## Engineers Comments Regarding Surface Water Drainage

| <b>Application Reference:</b>   | A/153/25/DOC                                                                                                                                                 | <b>Reviewer Reference:</b> | ADC/EXT5/AF |
| <b>Site Name:</b>               | Land North of Water Lane Angmering BN16 4EJ                                                                                                                  |                            |             |
| <b>Application Description:</b> | Approval of details reserved by condition imposed under A/88/24/S73 relation to condition 5-drainage arrangements for bund along Northern boundary with A27. |                            |             |

NORTHERN NOISE BUND
CATCHMENT AREA

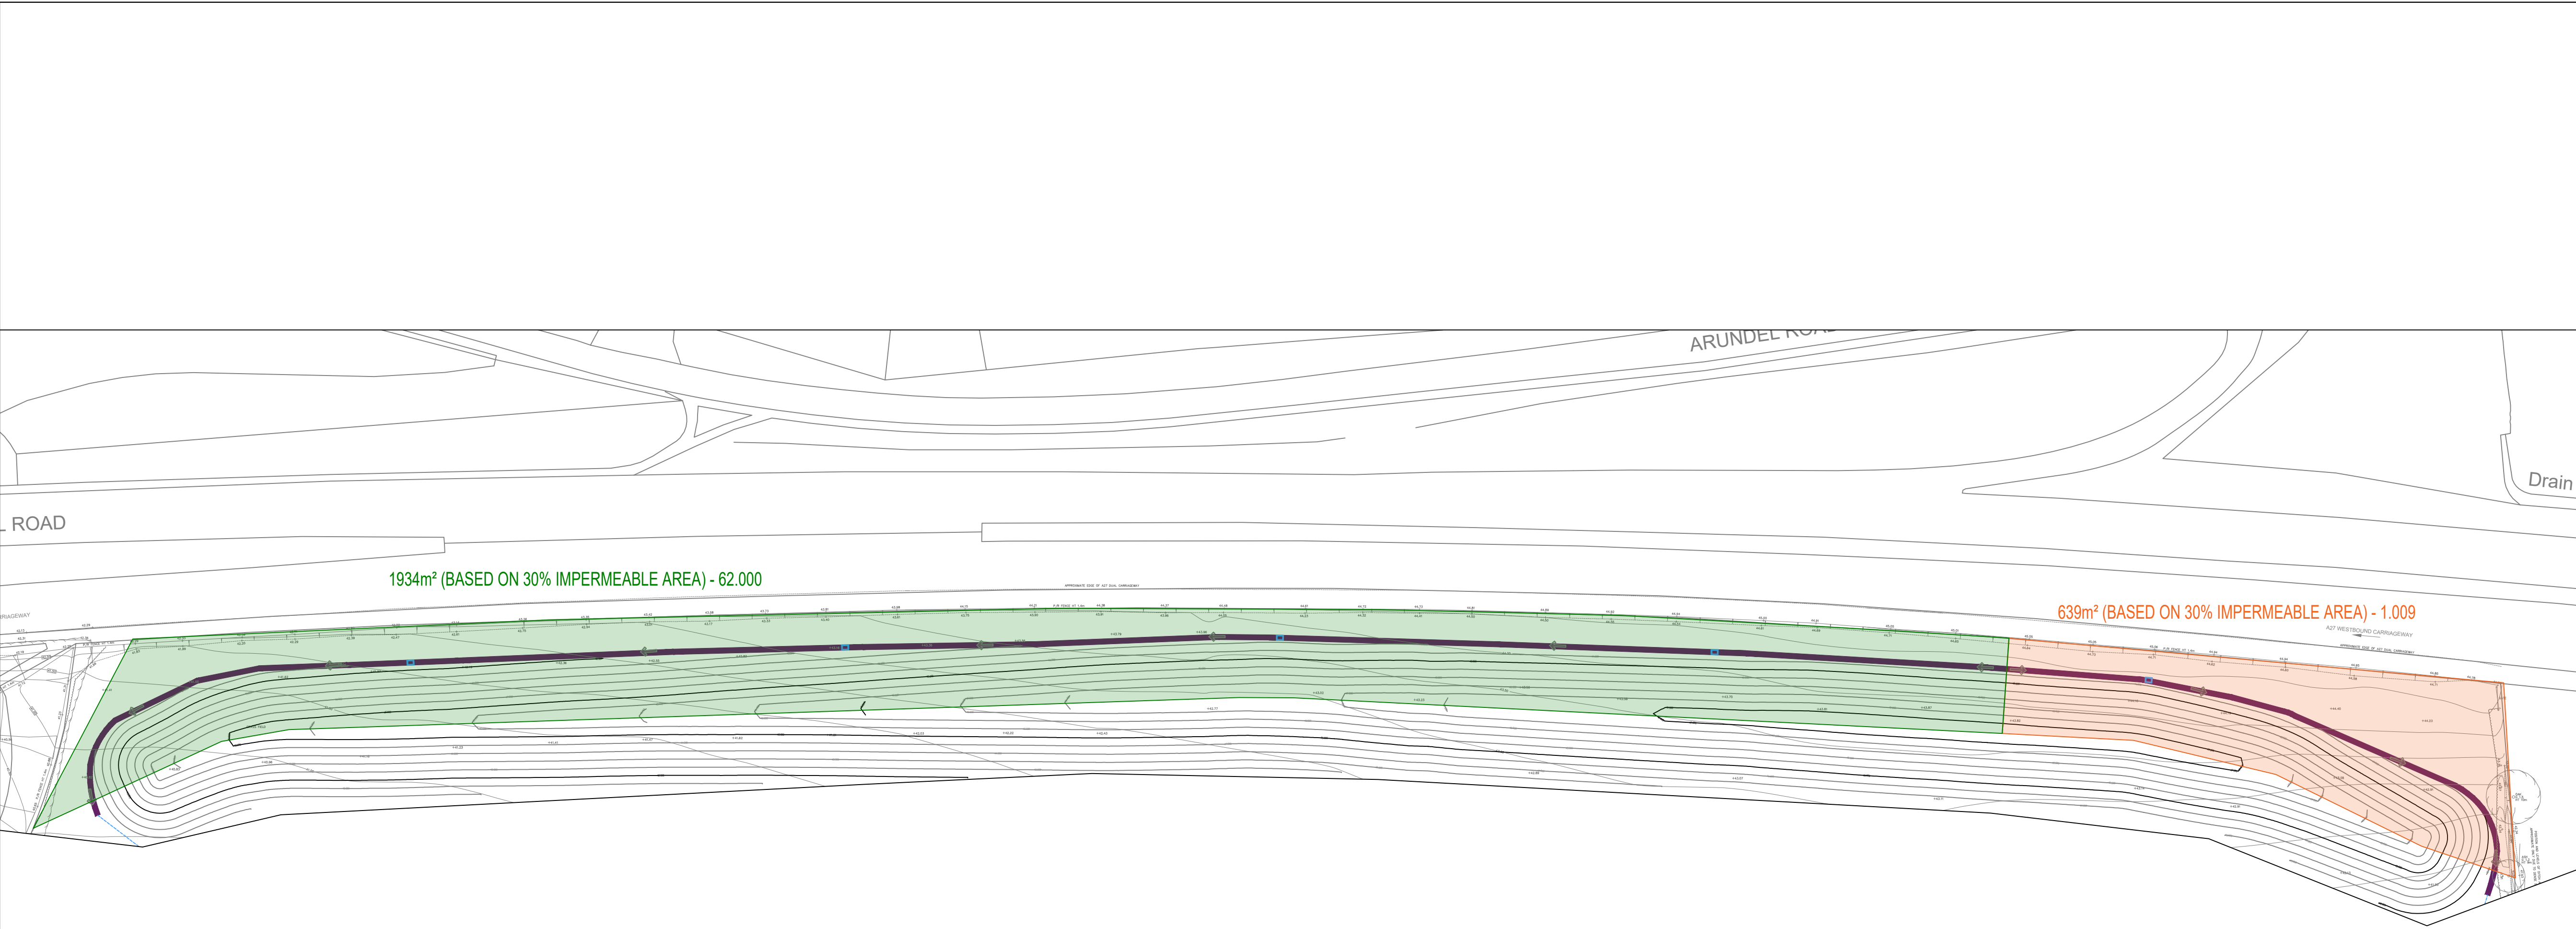
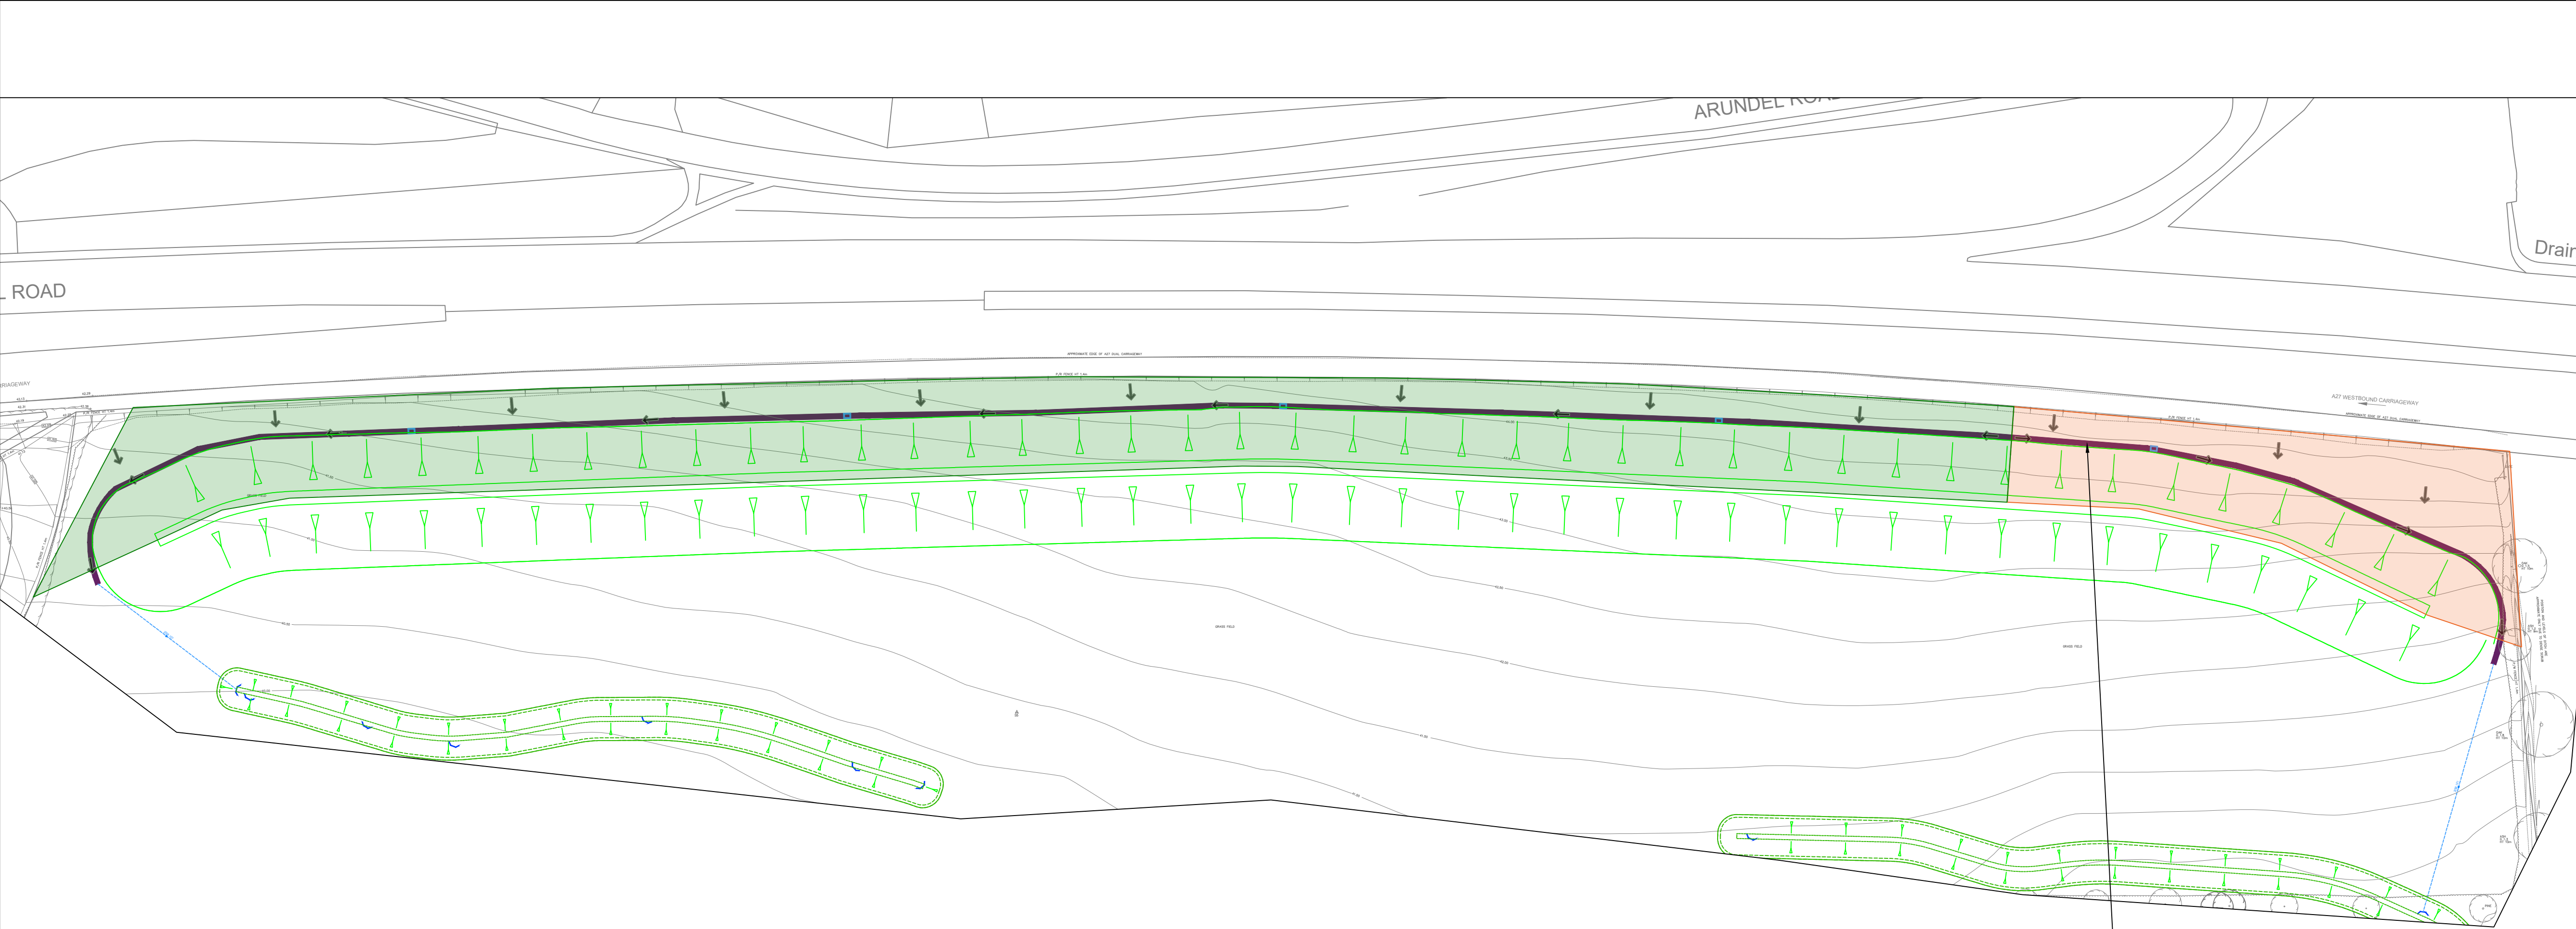
|                            | ADC Drainage Comments                                                                                                                                                                                                    | ADC Drainage Comments                                                                                                                                                                                                                                                                                                                       | ADC Drainage Comments                                                                                    |  |  |
|----------------------------|--------------------------------------------------------------------------------------------------------------------------------------------------------------------------------------------------------------------------|---------------------------------------------------------------------------------------------------------------------------------------------------------------------------------------------------------------------------------------------------------------------------------------------------------------------------------------------|----------------------------------------------------------------------------------------------------------|--|--|
| 2.                         | Please provide calculations confirming the capacity of the filter drain and also the capacity of the swale where the filter drain is discharging to. Additional flows from the development should be taken into account. | Calculations do not include addition of filter drain.<br><br>Impermeable areas plan does not match calculation pack for noted outfall locations. PN 62.000 on calculation pack has impermeable area 0.033 Ha. Drawing shows impermeable area 0.193 Ha.<br><br>PN 1.009 noted as swale on drawings, noted as 450mm pipe in calculation pack. | The calculations and Northern Noise Bund Catchment Area plan are now correct.<br><br>No further comment. |  |  |

|    |                                                                                                                                                                                            | <p>PN1.009 noted as having 0.063 Ha. area on drawing and 0.055 Ha. On application pack.</p> <p>Please provide updated calculation pack with supporting catchment plan to ensure the areas are properly considered.</p> |                     |  |  |
